# CITY OF PORTLAND BUILDING PERMIT

**PERMIT ID:** 2012-65702

86 Commercial St - 6 Custom House Wharf

has permission to **Interior renovations for new restaurant 1st & 2nd floors (change of use for 2nd floor), including structural upgrades to beams, columns & wharf bents and 2nd floor exterior deck w/outside dining on both decks (internal demo permit #2012-10-5242)**

DECK FOUNDATION PLAN

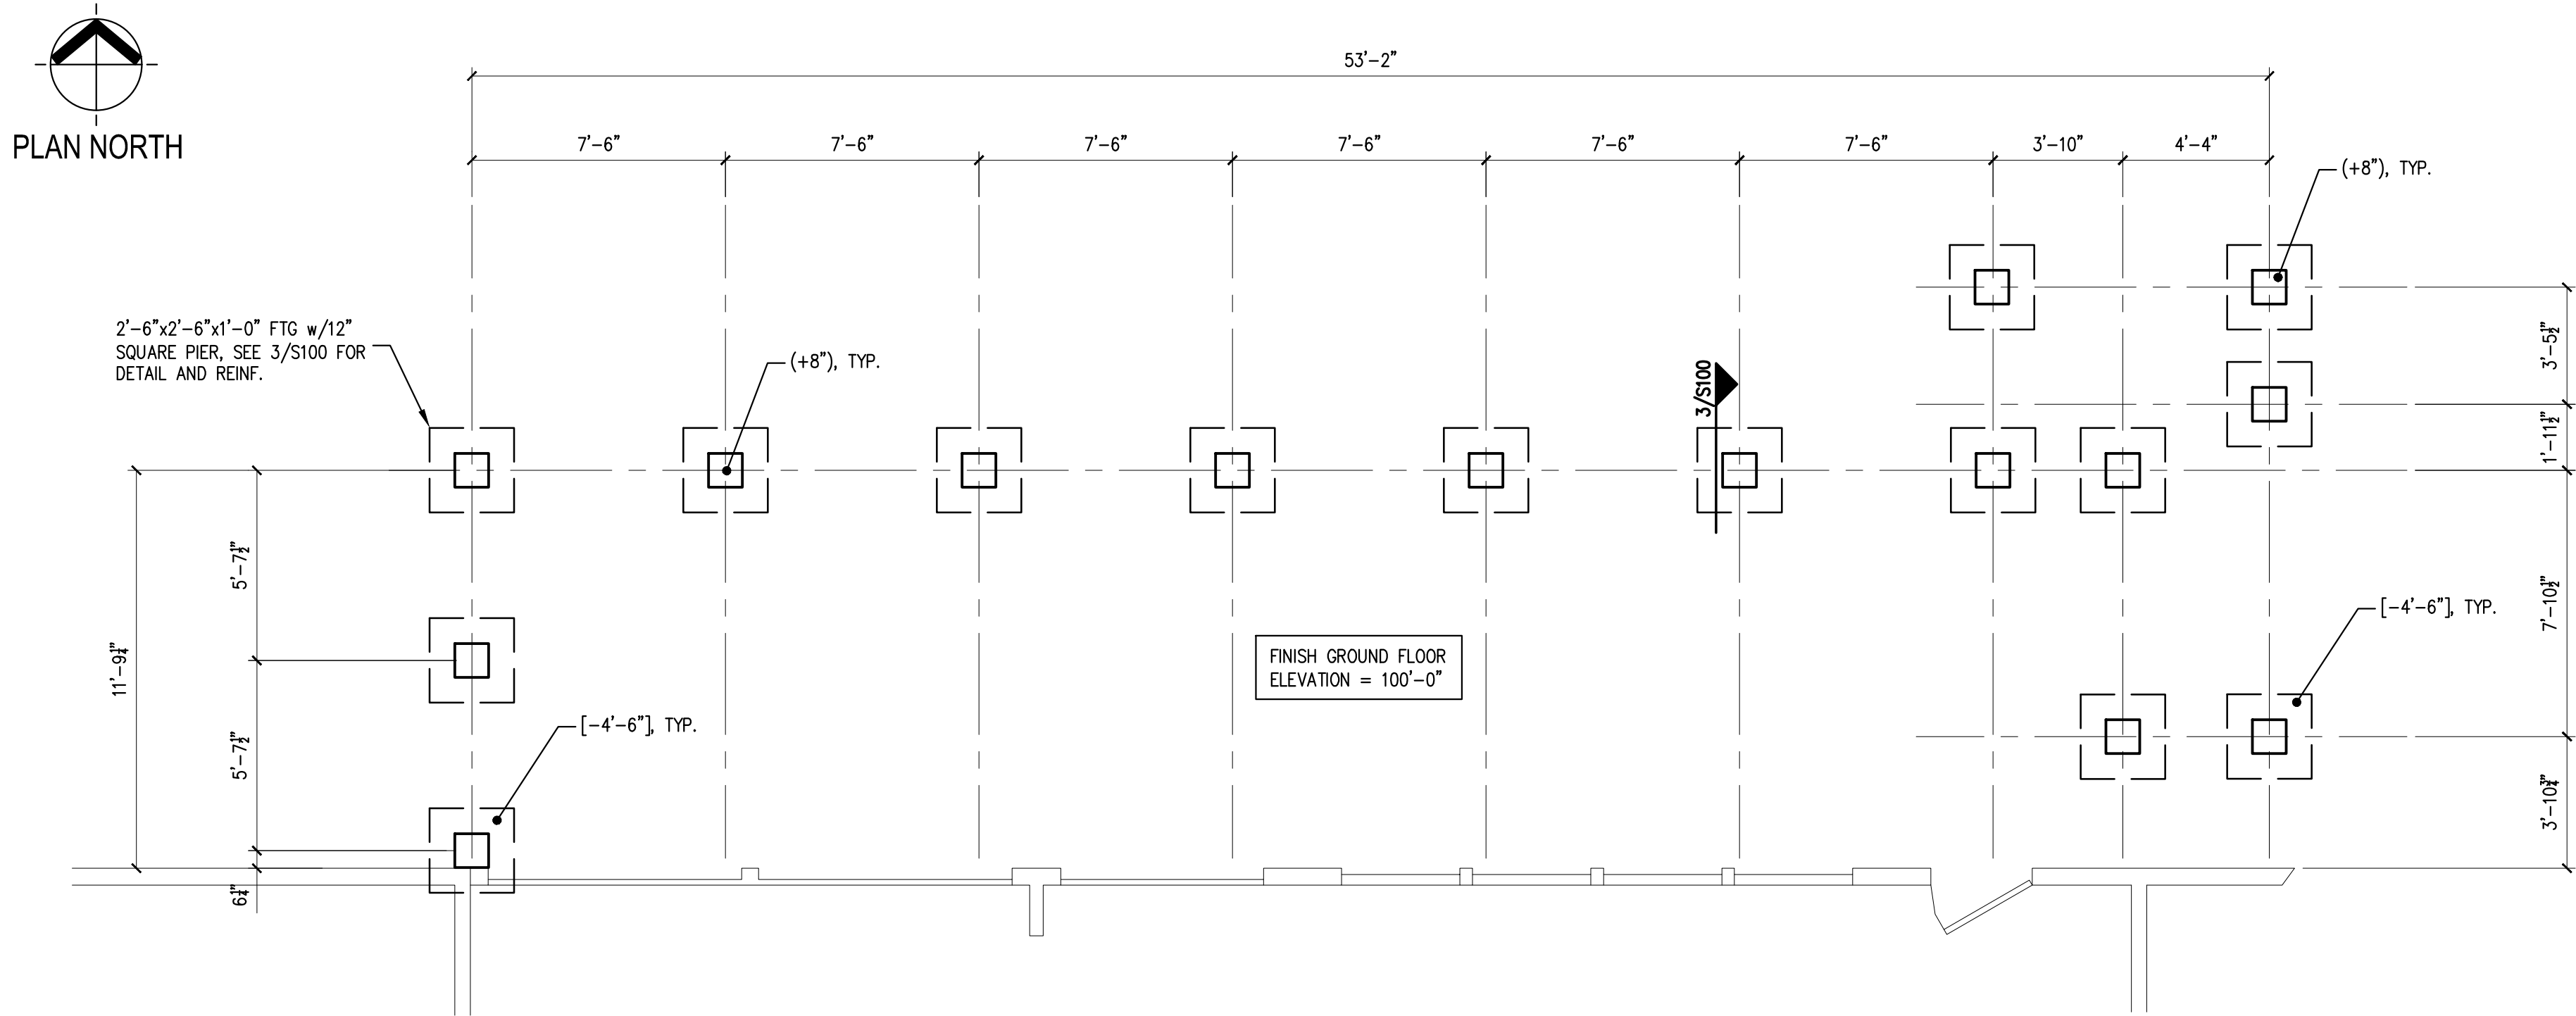
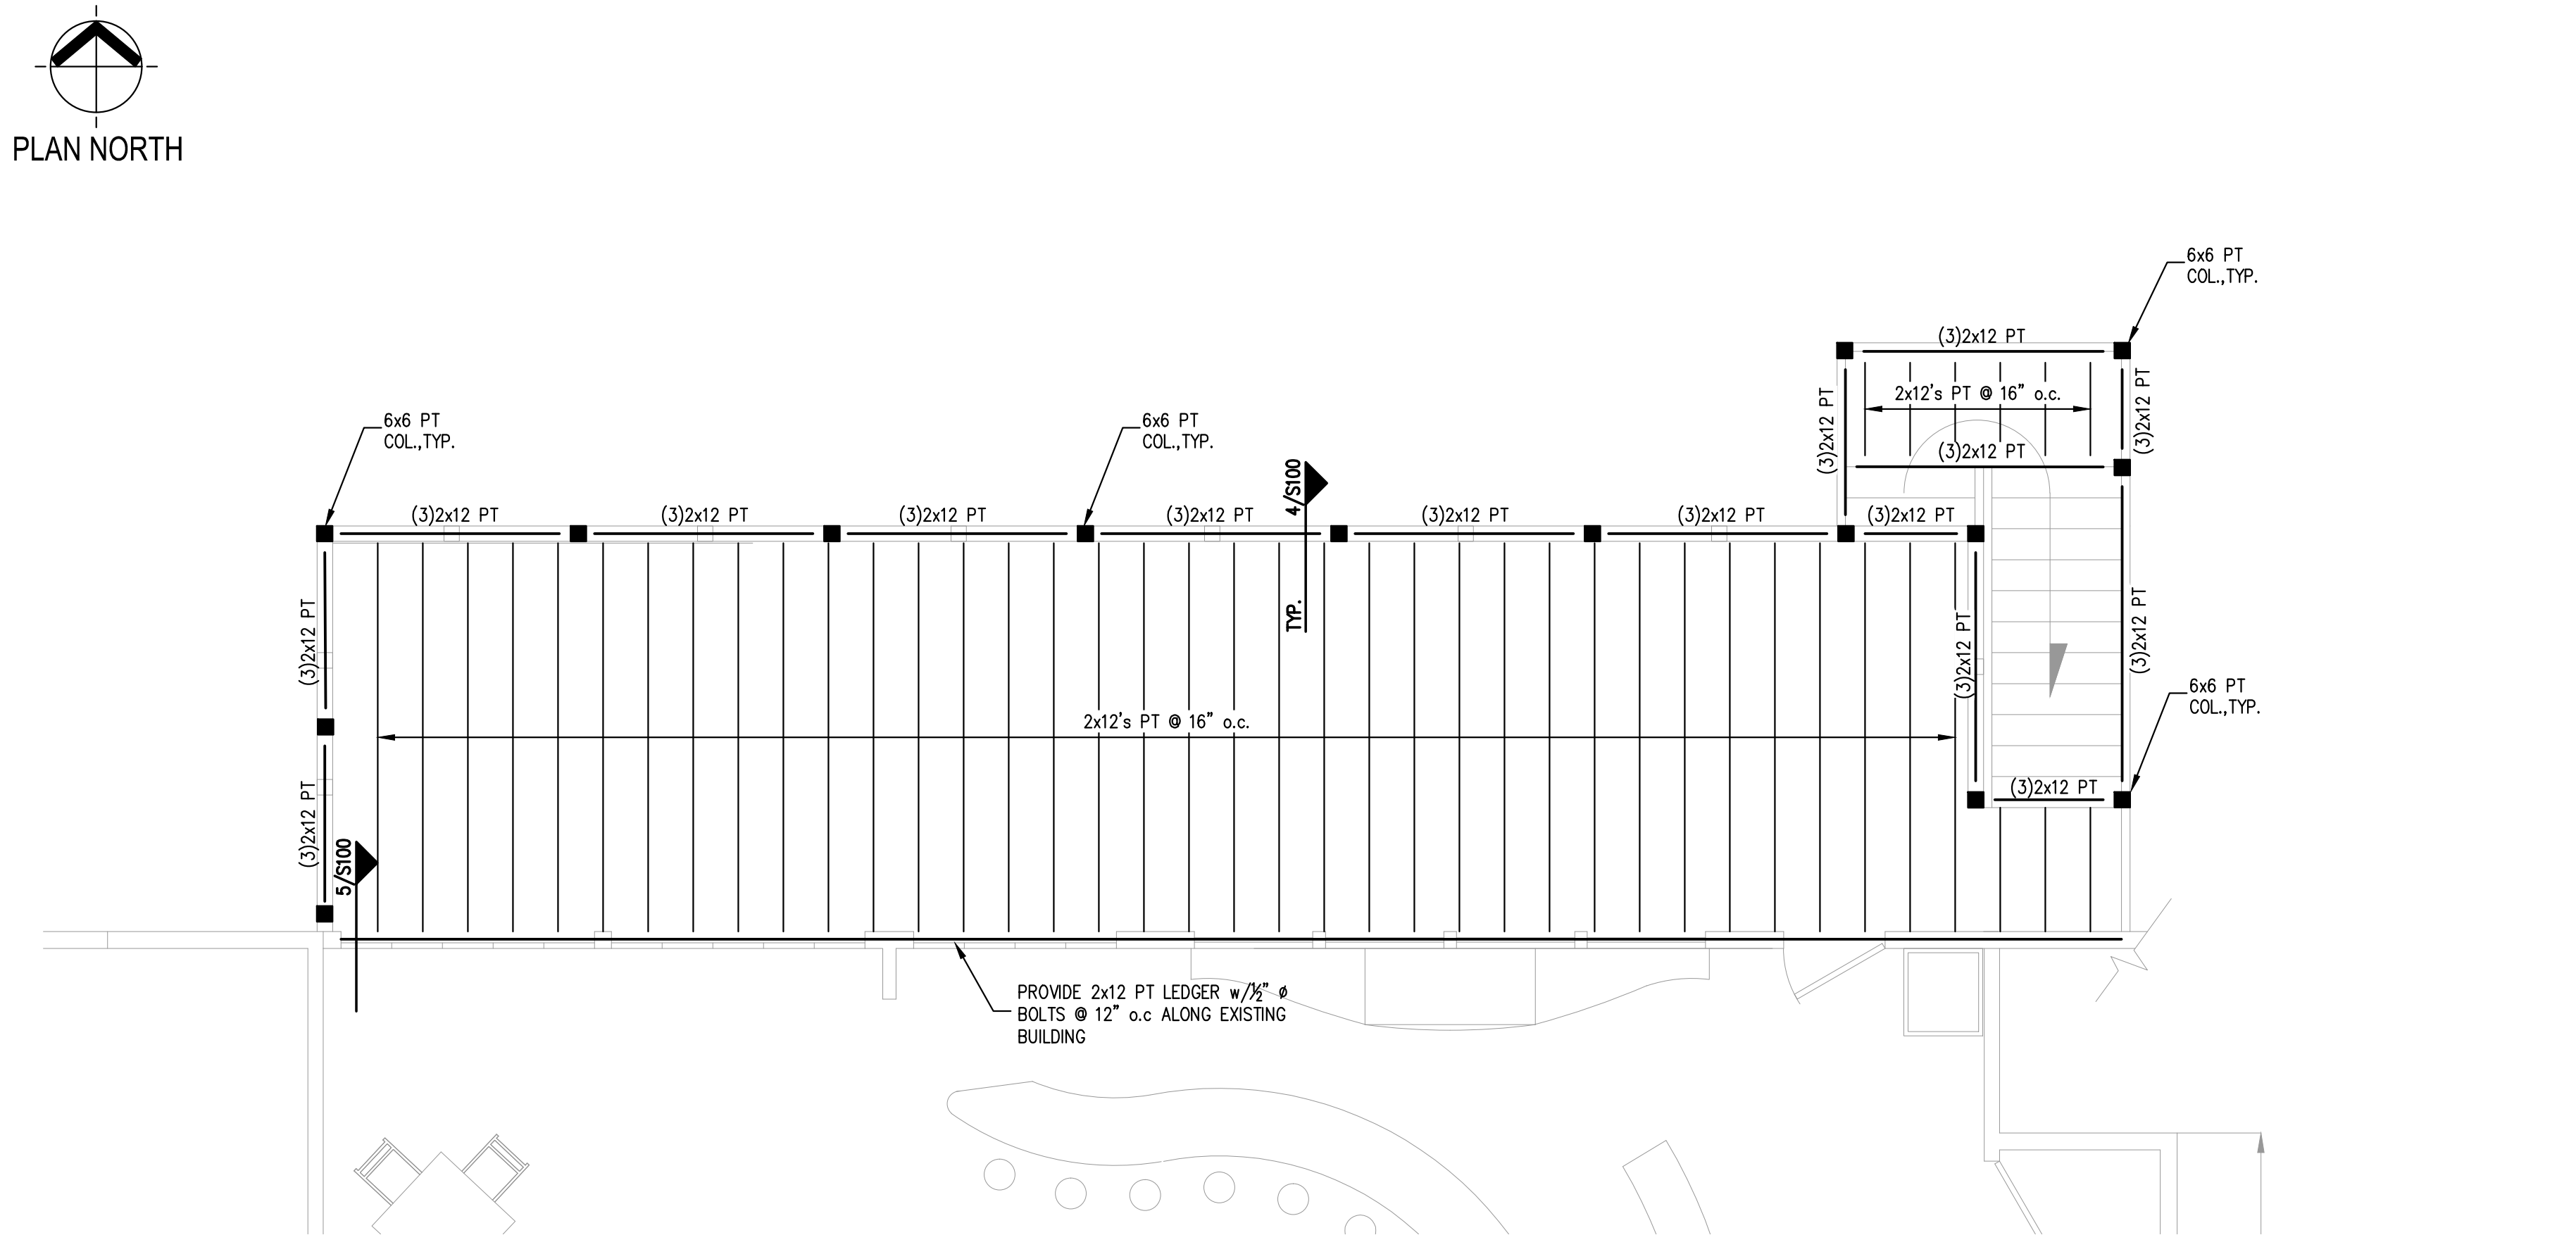
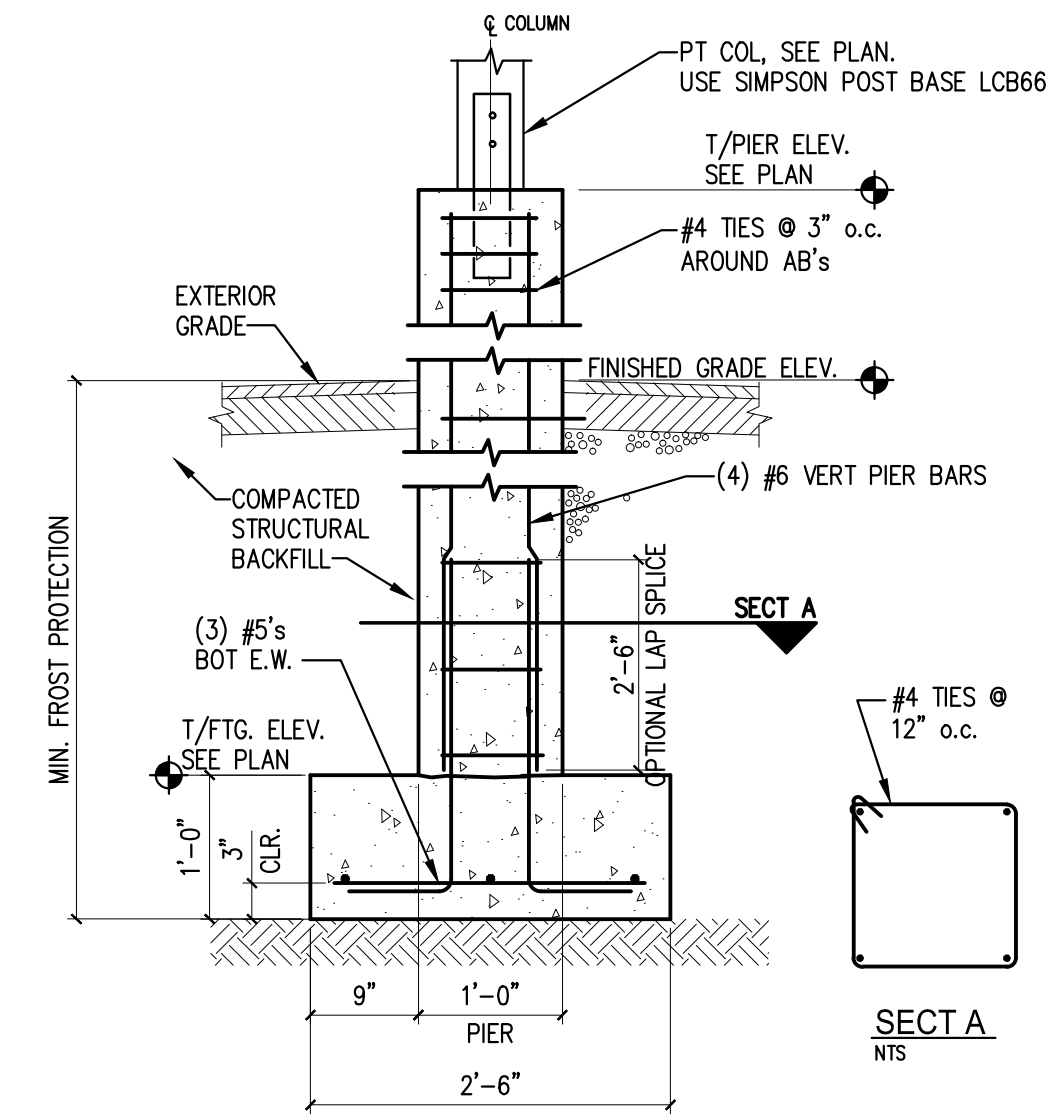
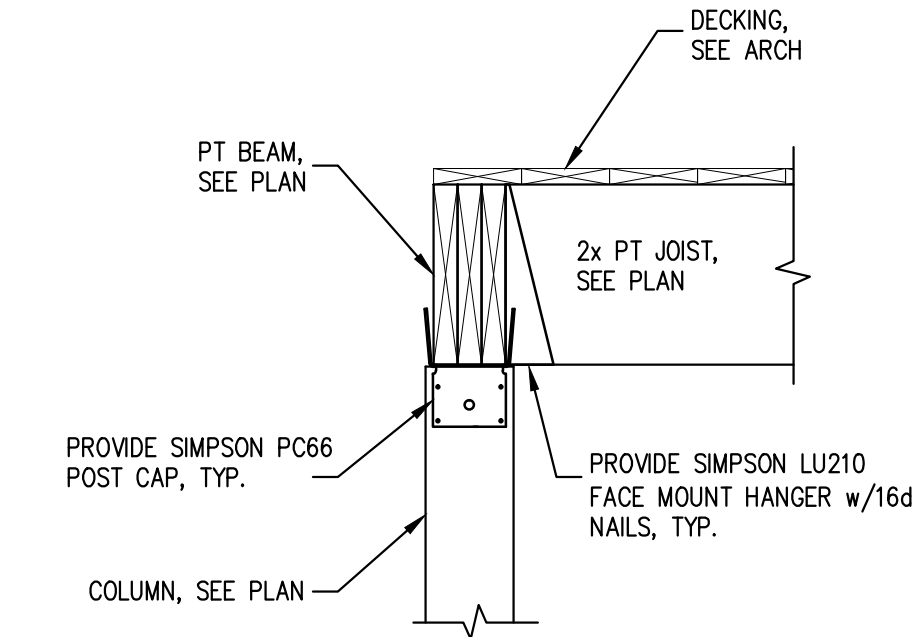
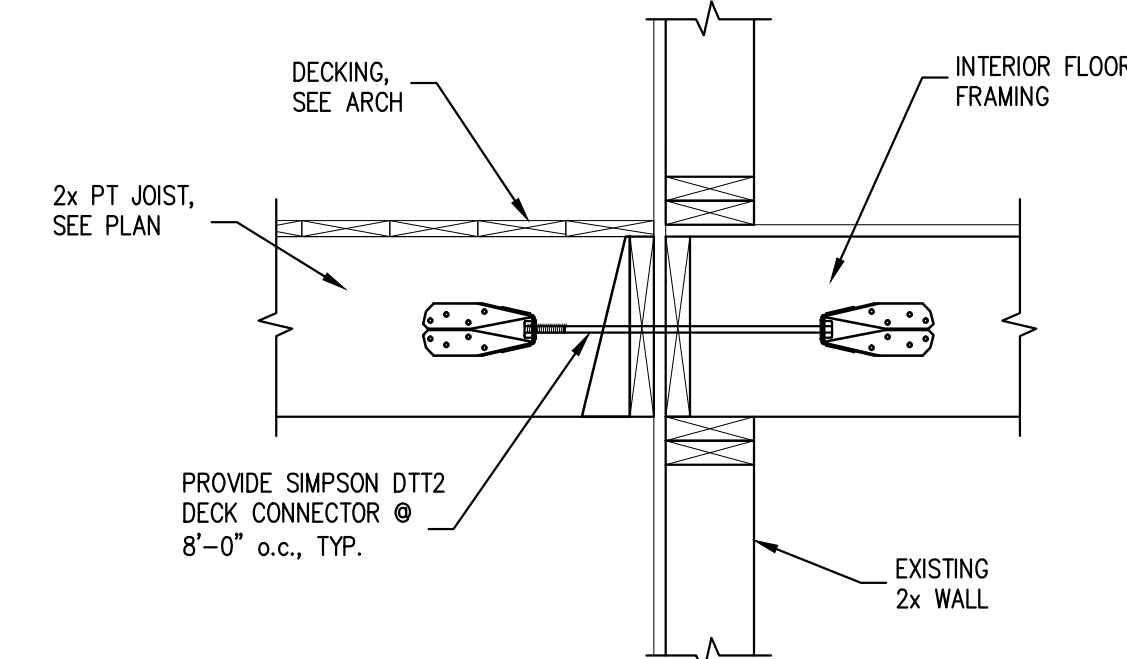
- 3) Structural Plans S000 and S100 are approved for framing only. The footings for the posts are not included in the scope of work, the detail for the 2nd floor deck bearing posts shall be submitted to this office prior to this work commencing. An analysis shall be performed by a structural engineer with details on the proposal to carry these posts on the existing beam or pilings below.
